I68 Training Facility, PPR-24-40

Please accept the following comments from El Paso County Public Health for the project referenced above:

SITE DEVELOPMENT PLAN FOR 168 TRAINING FACILITY

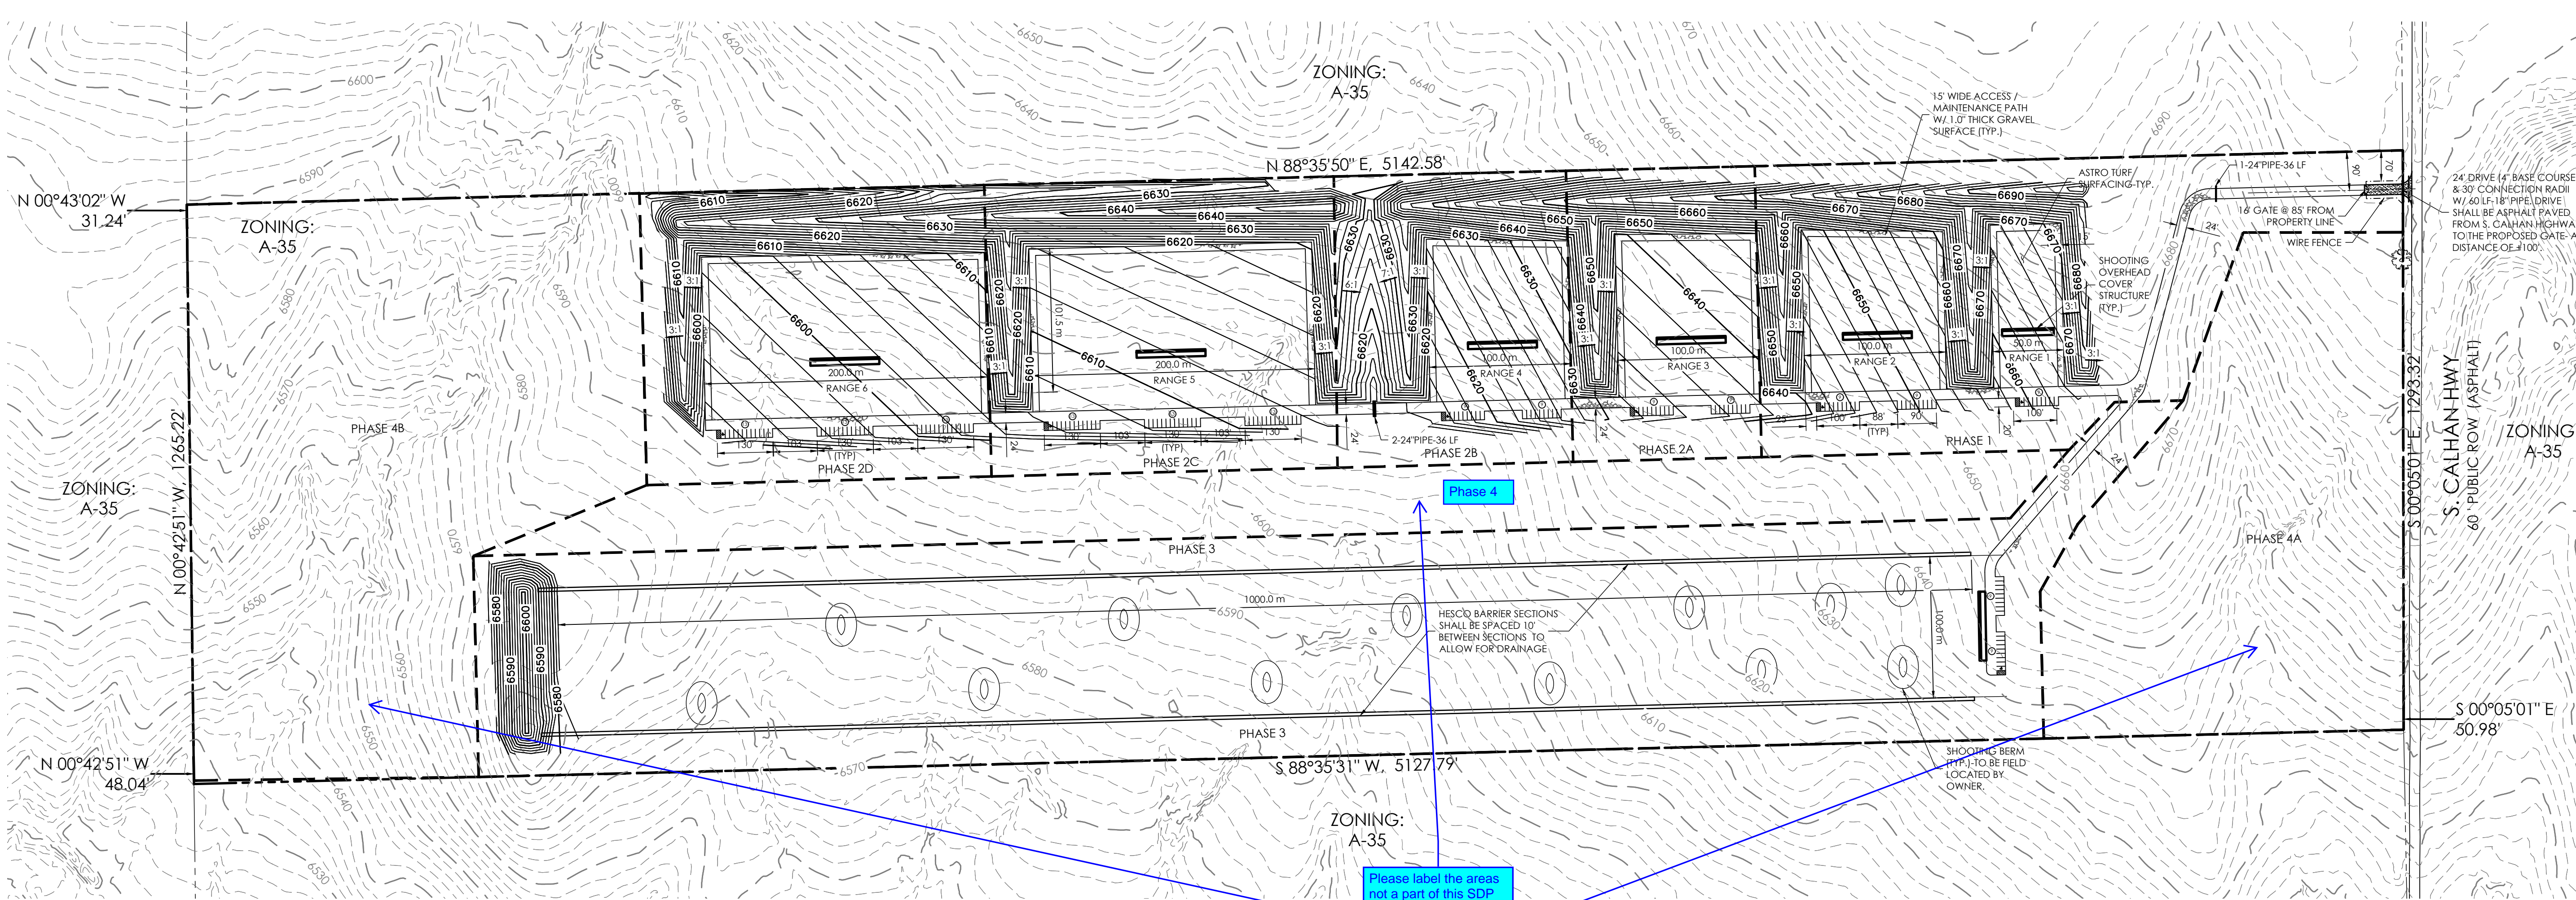
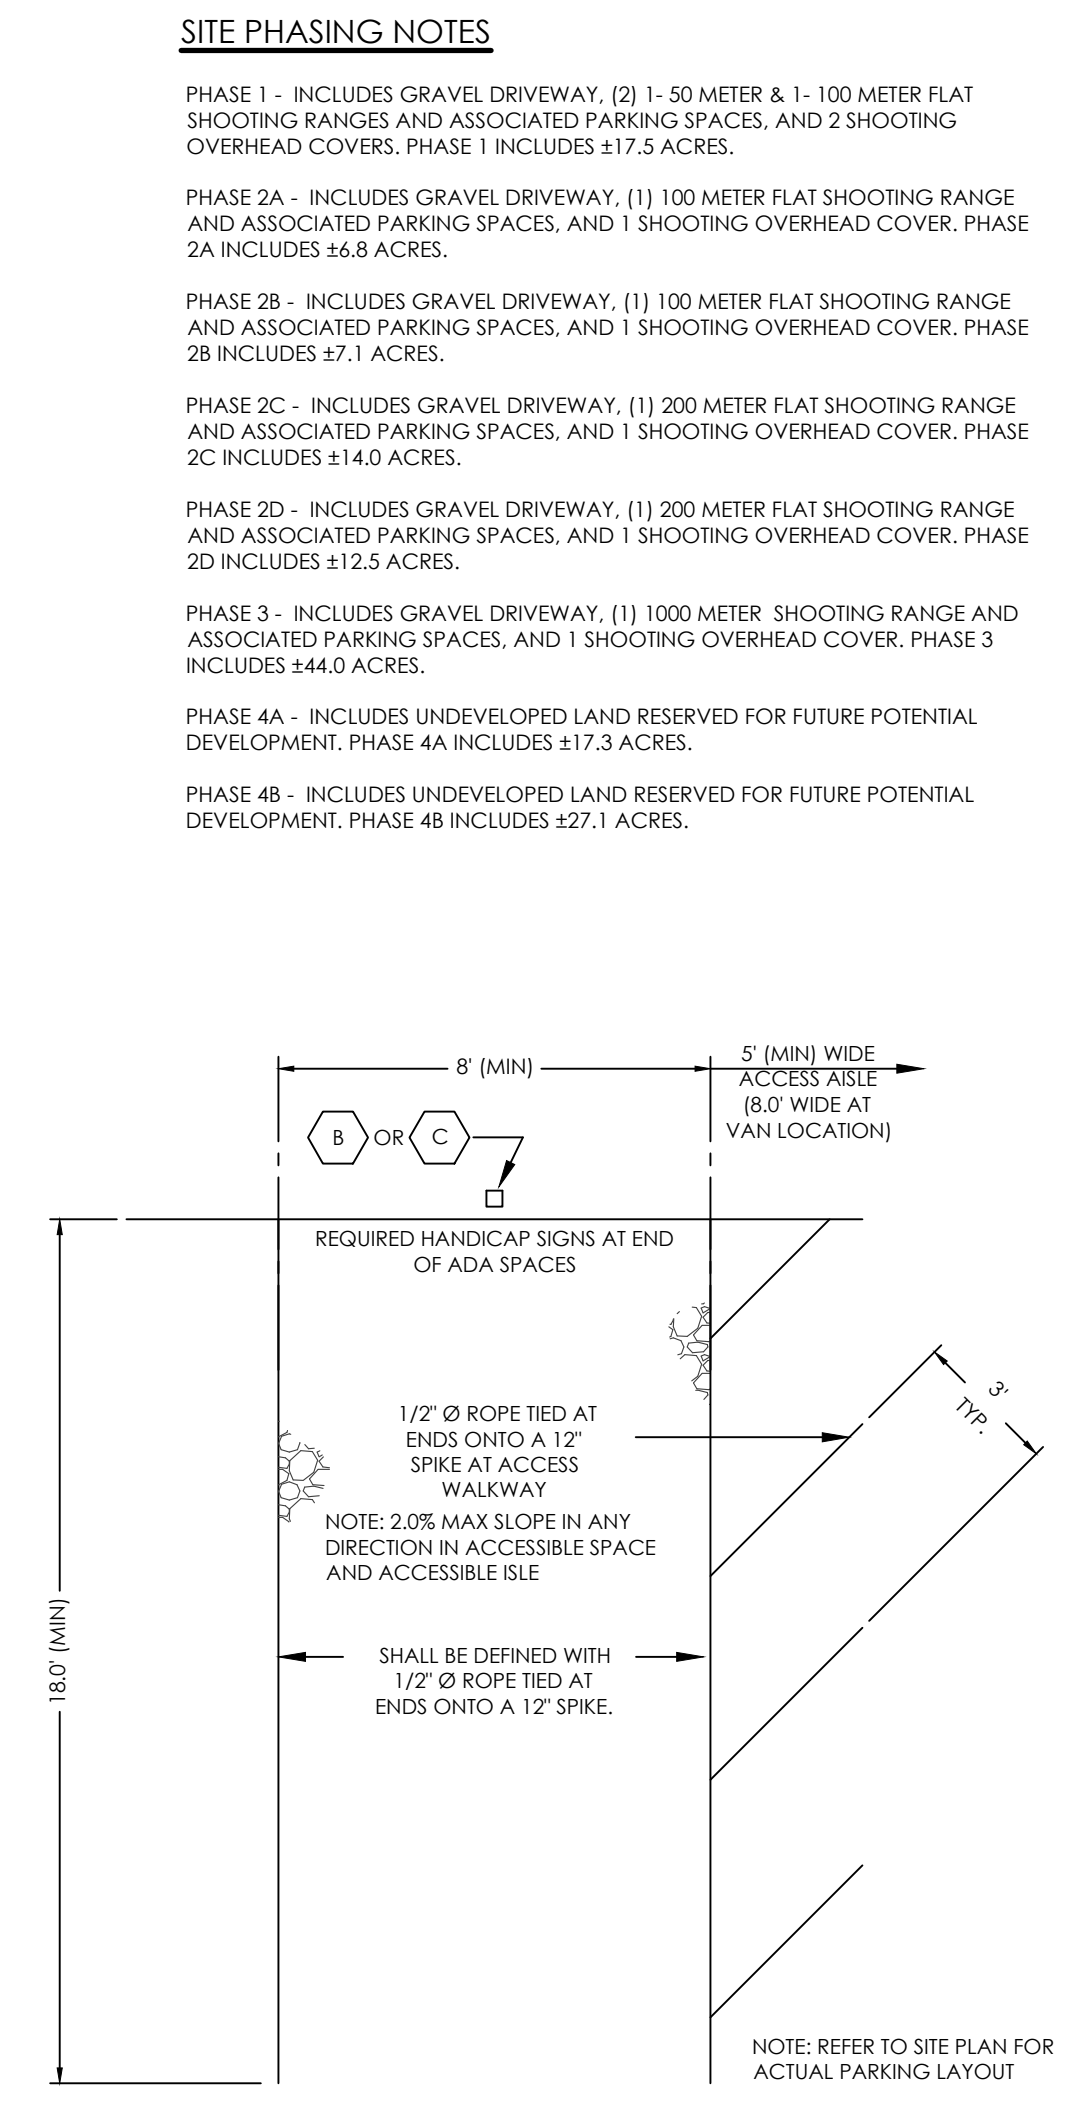
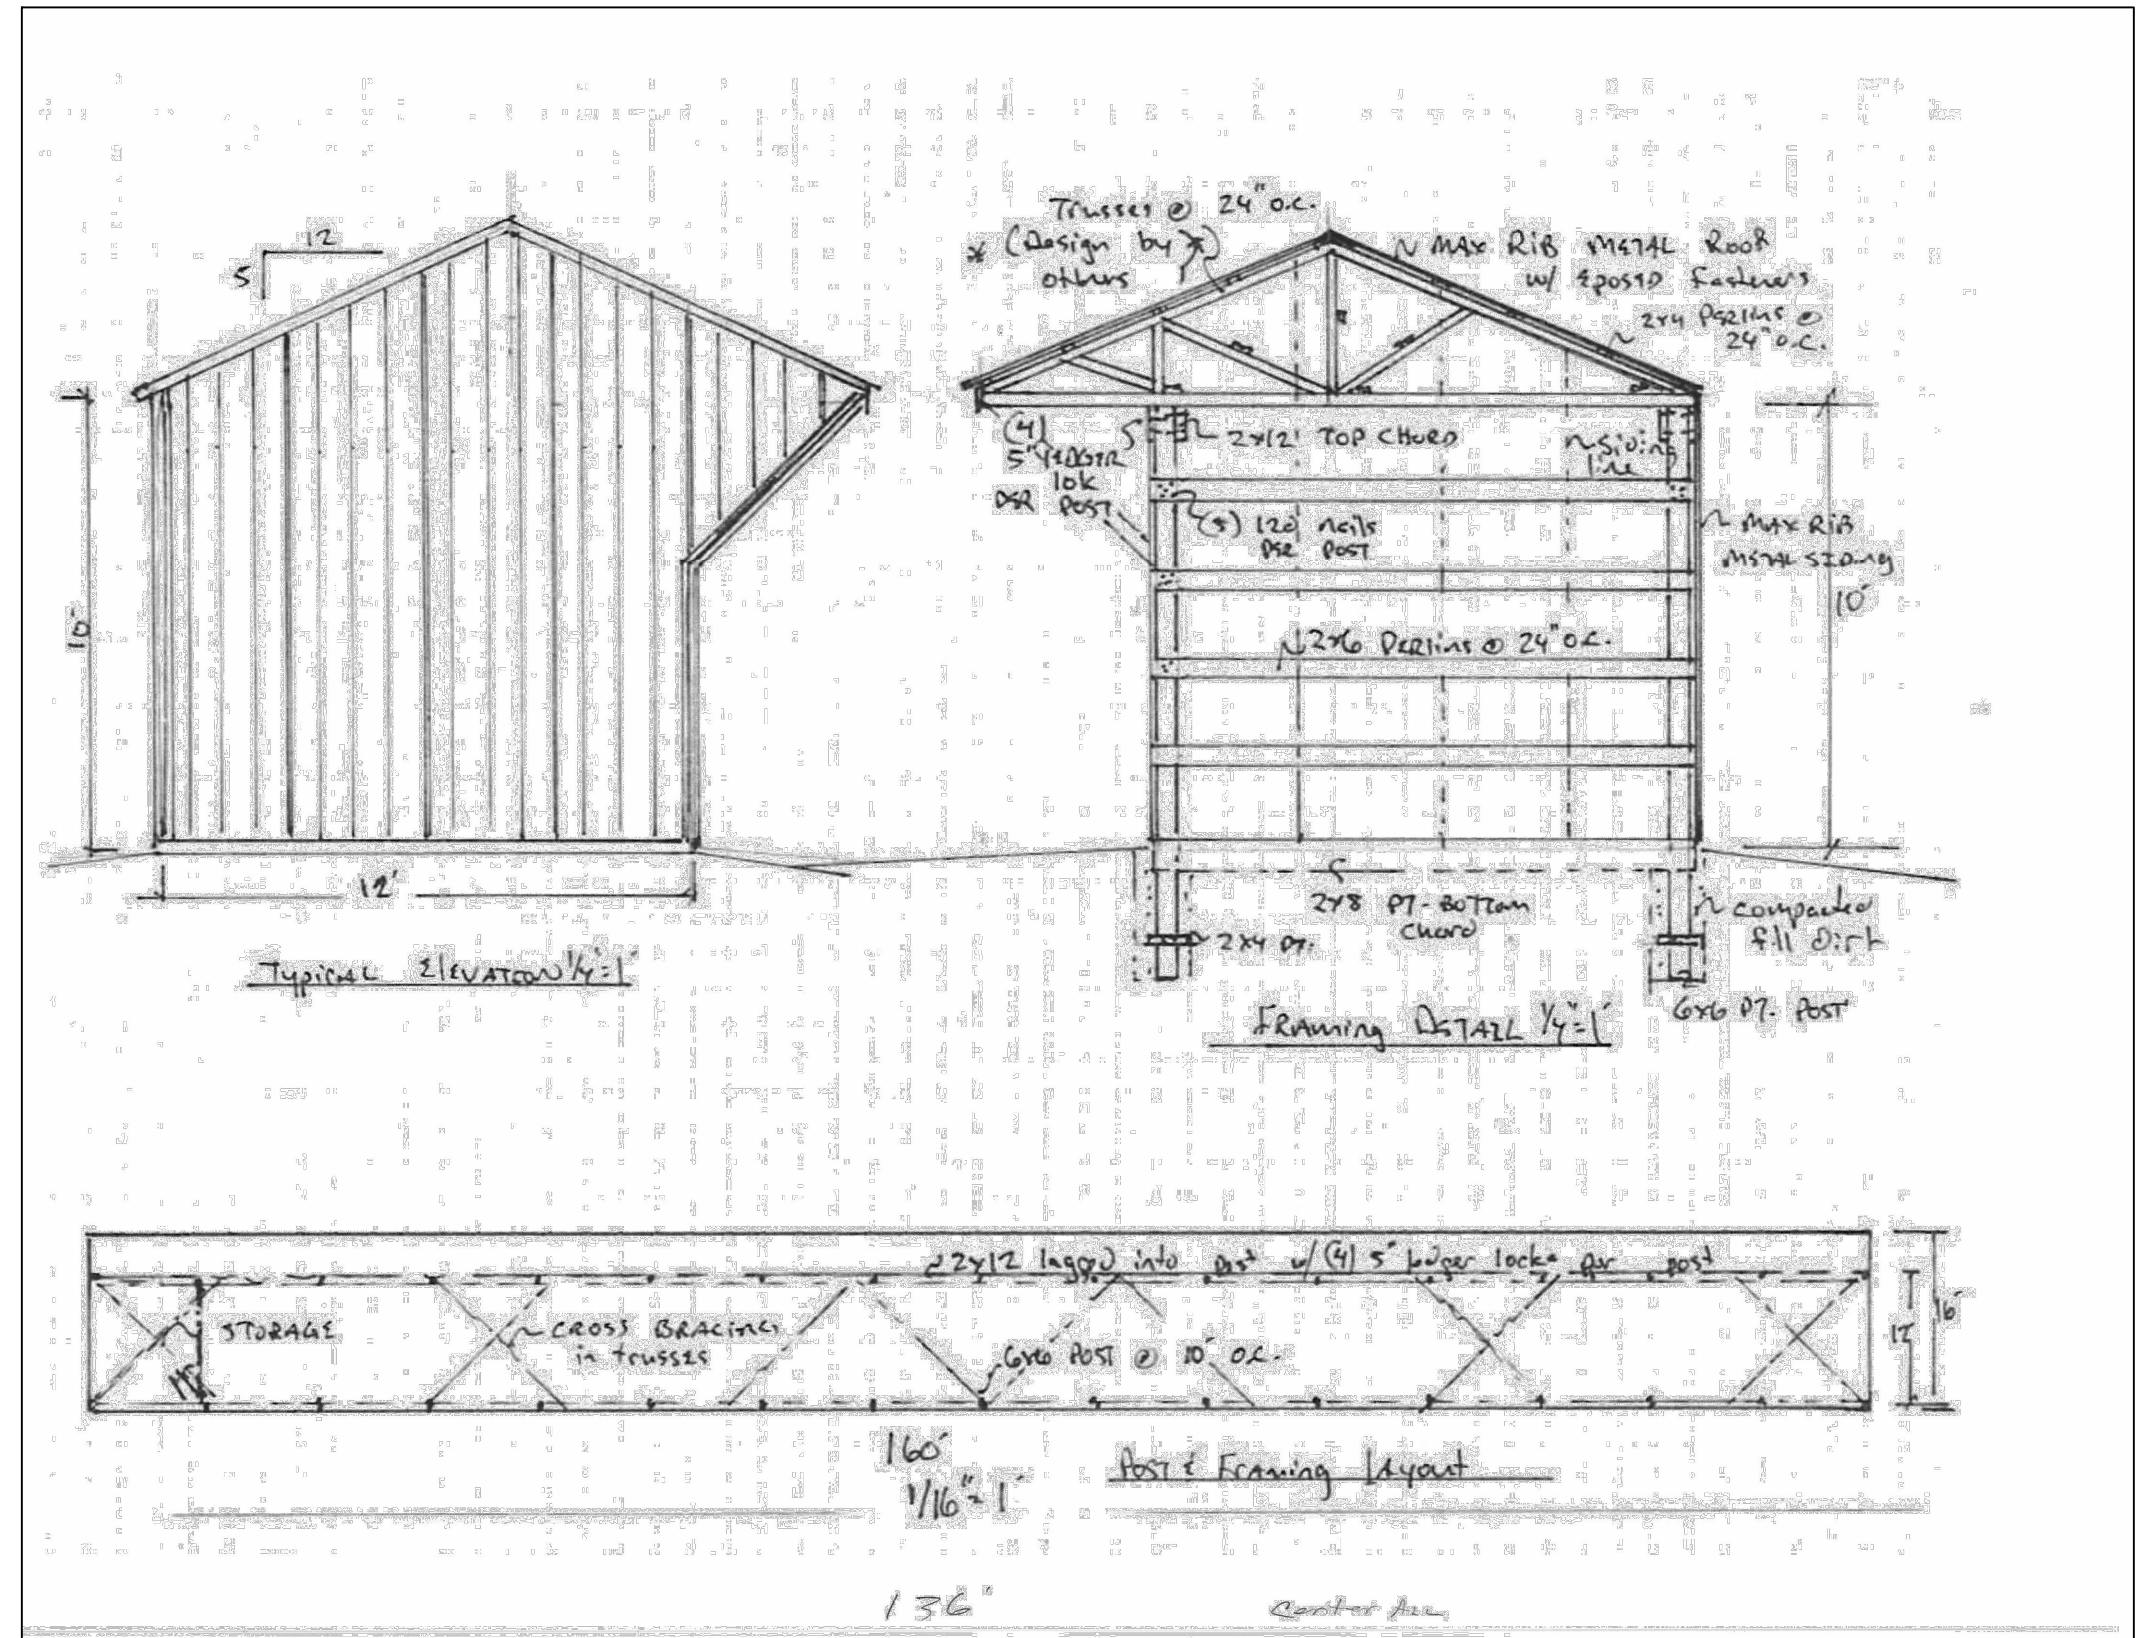
- **The Phase 4 site plan shows an Admin/Classroom, lodging, and showers. This phase of development, if not in an earlier phase, will require the installation of a professional engineer designed onsite wastewater treatment system (OWTS) and full compliance with the El Paso County Public Health, Onsite Wastewater Treatment System Regulations. A more comprehensive water and wastewater service plan is advised to be planned prior to future phasing submittals.**
